STATE OF NORTH CAROLINA  
DEPARTMENT OF TRANSPORTATION

**Addendum No. 2**

RE: Contract ID: C202837

**Wayne County (R-2554A)**

## PROFILE ALONG WALL 2 AT -L2RPB- STA. 6+40.0

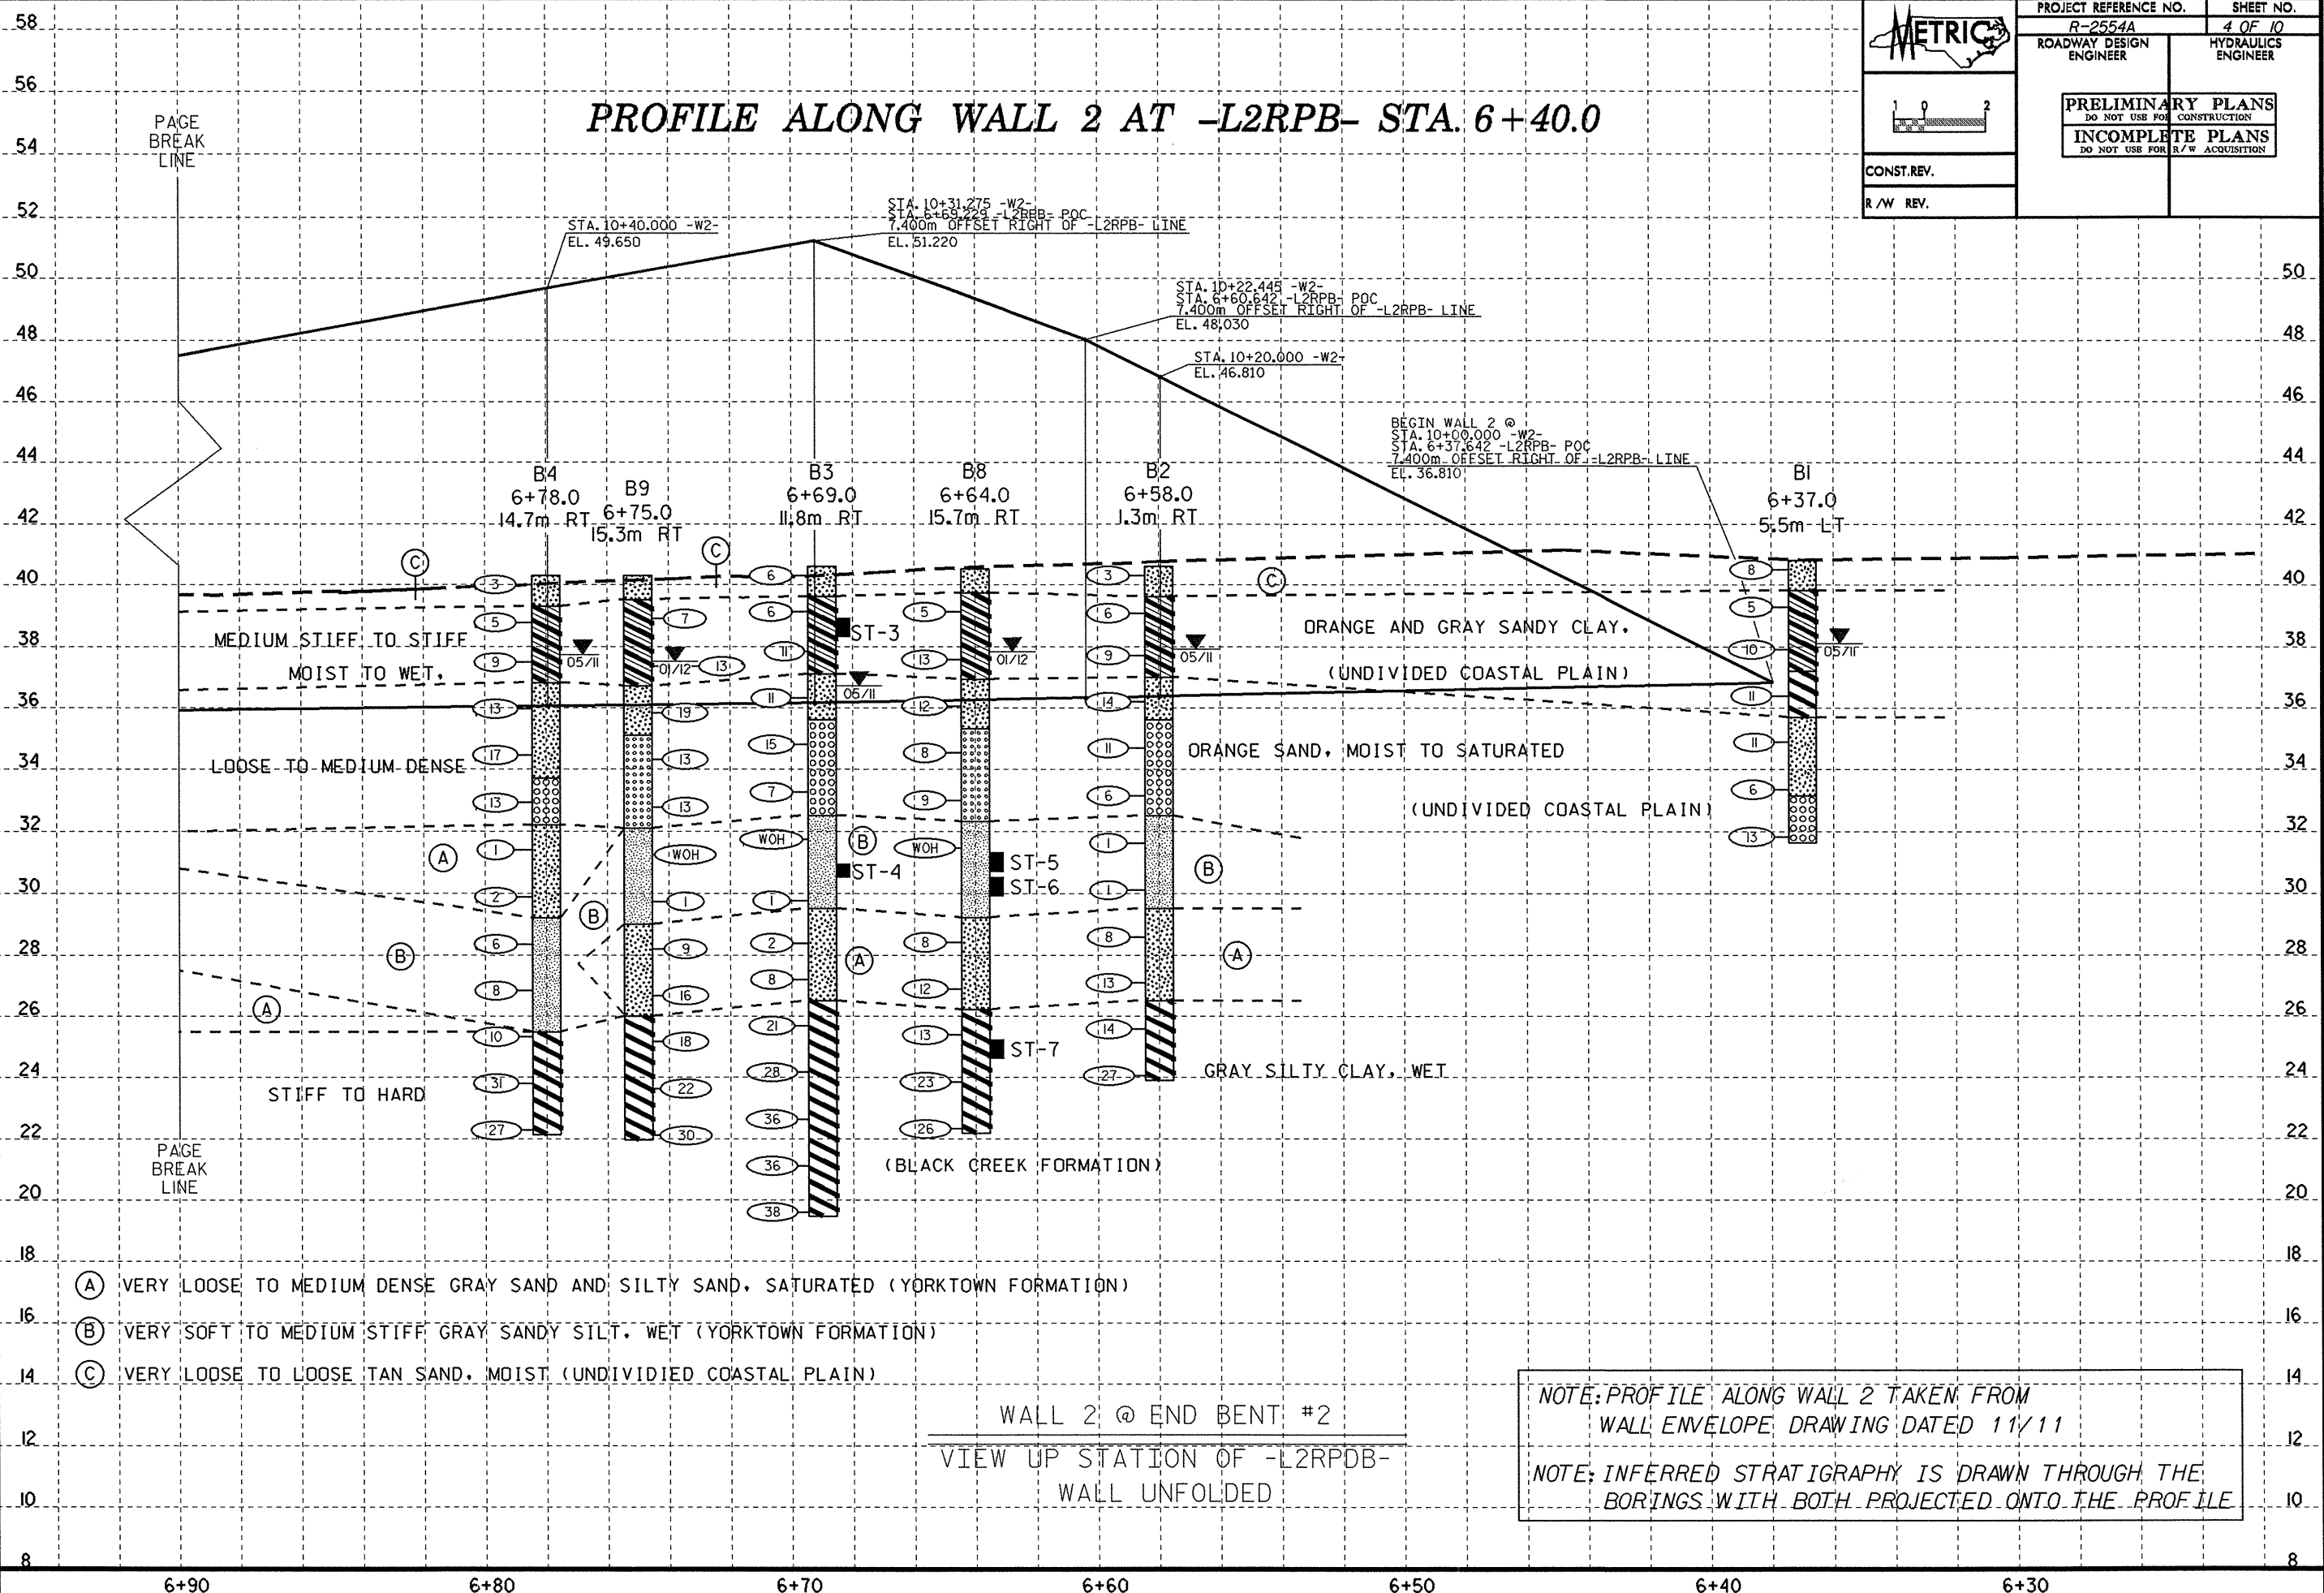
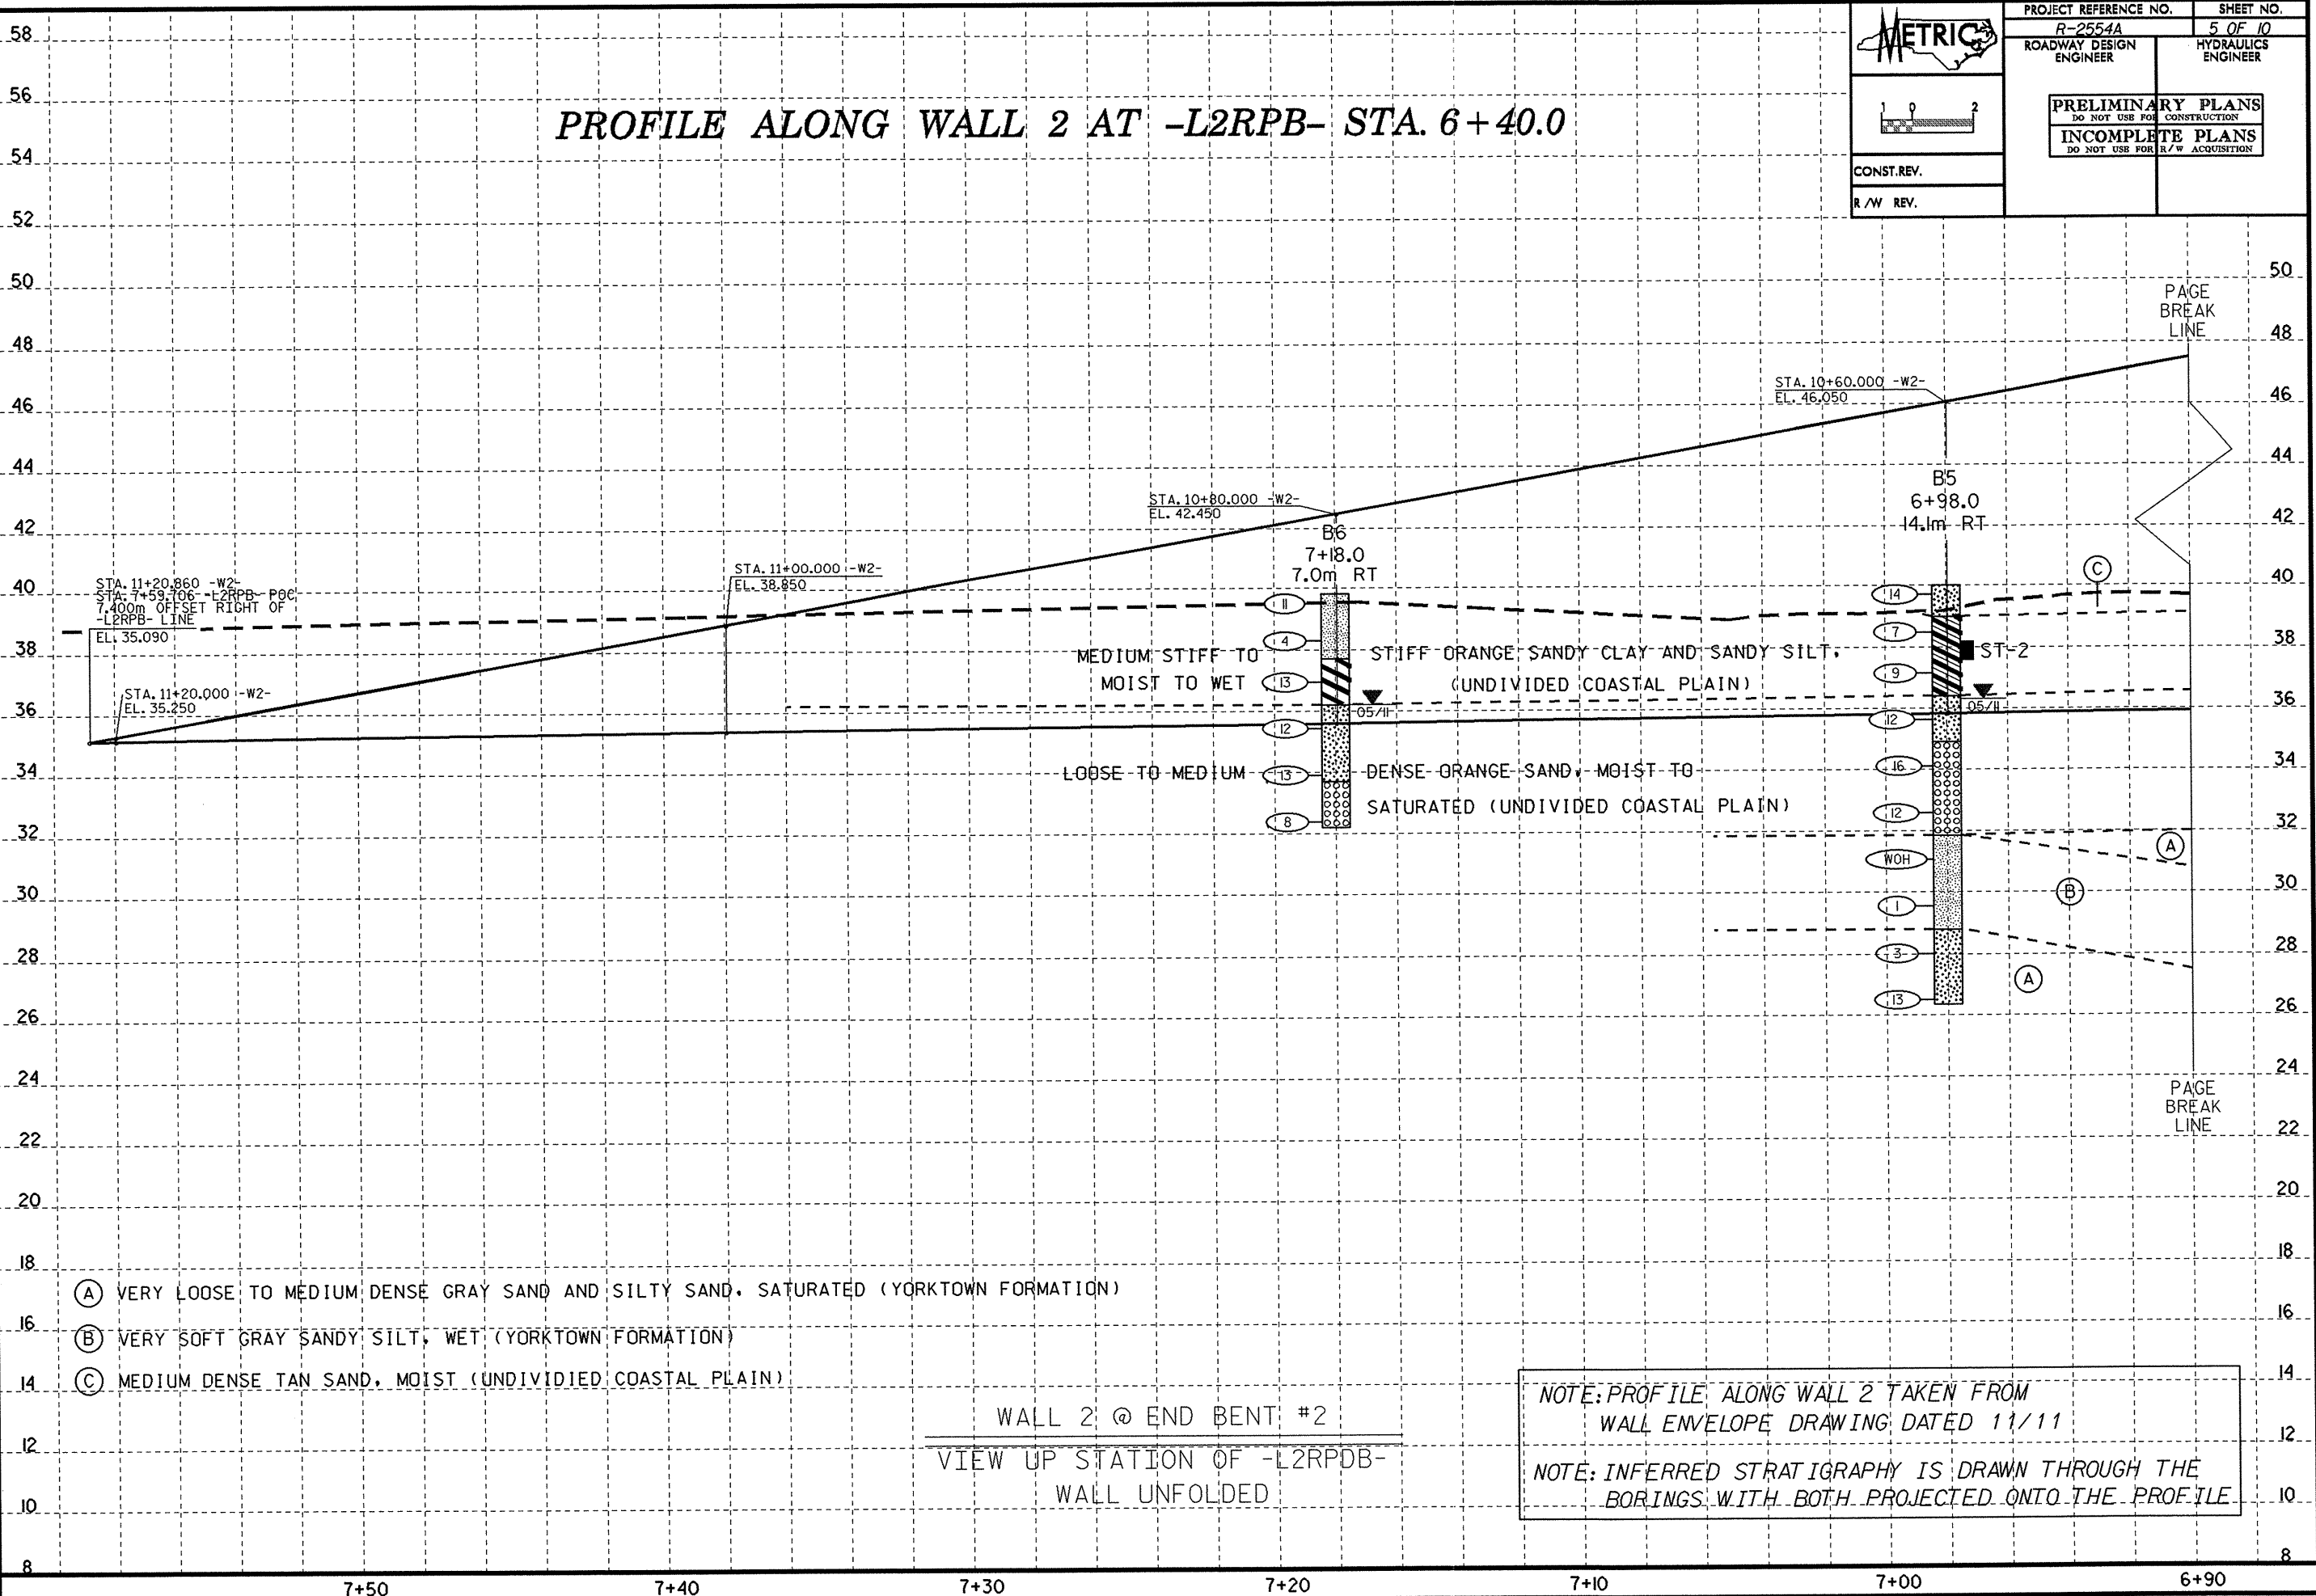
The sheets for “Retaining Wall 2 At End Bent 2 At –L2RPB- Sta. 6+40.0” have been revised due to additional borings being taken. Please void the sheets for “Retaining Wall 2” (10 sheets) and replace with the attached revised sheets for “Retaining Wall 2” (12 sheets).
